As discussed, Council has no specific comment regarding Cadia modification 10.

Council does ask that the project approval ensures that the intersection of Cadia Road and the new site access is constructed to the satisfaction of Council.

Blayney Shire Council

**Figure 3: Proposed Modification – Molybdenum Recovery Plant and Access Road design**

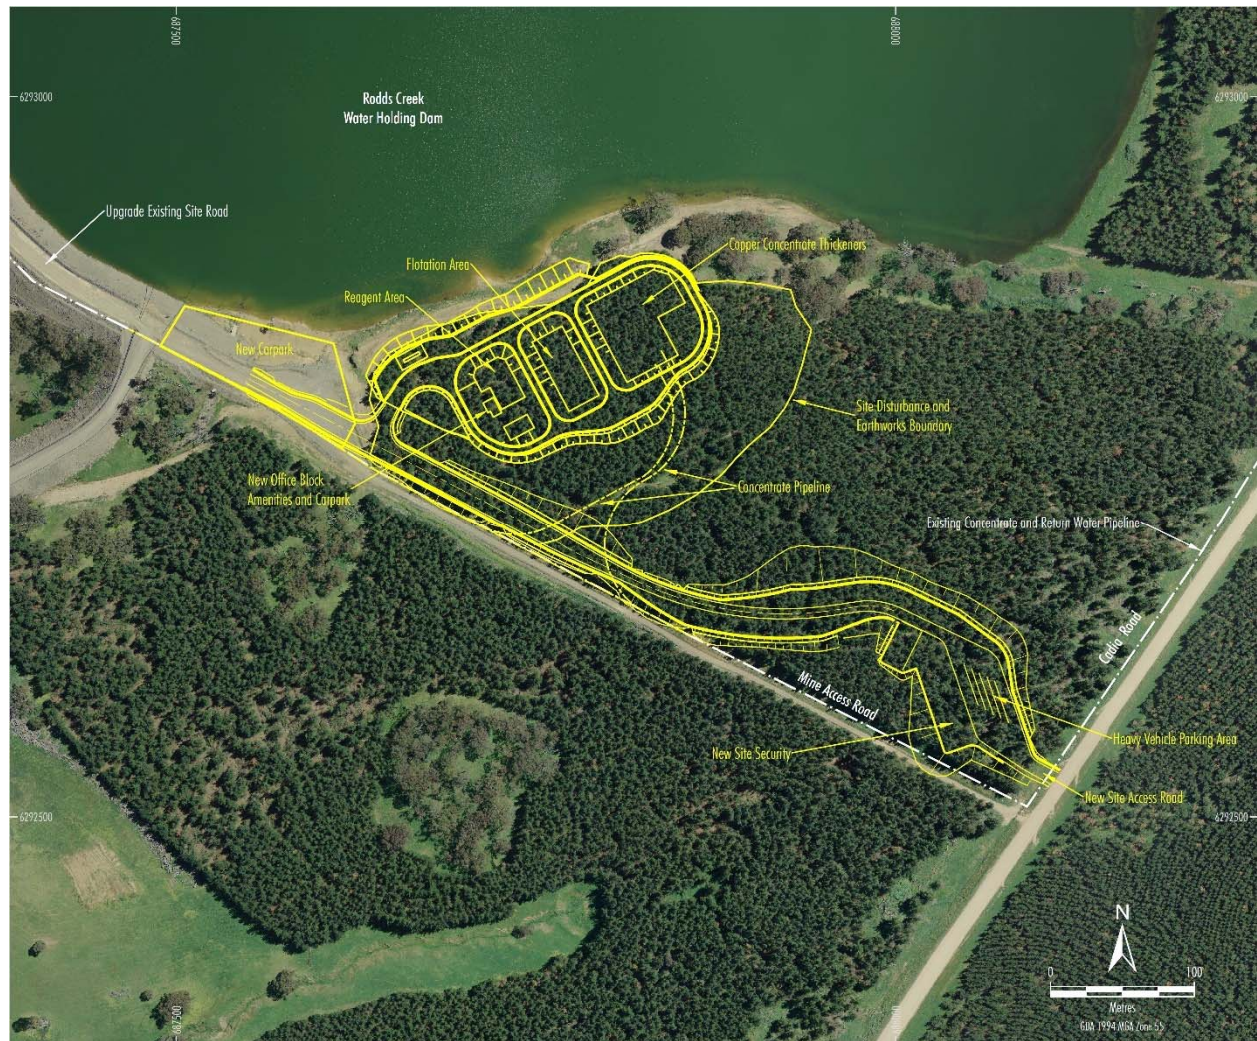
In this regard Council notes a Road Opening Permit under section 138 of the Roads Act 1993 is required to be obtained from Council prior to works commencing for the new site access road intersection with Cadia Road.
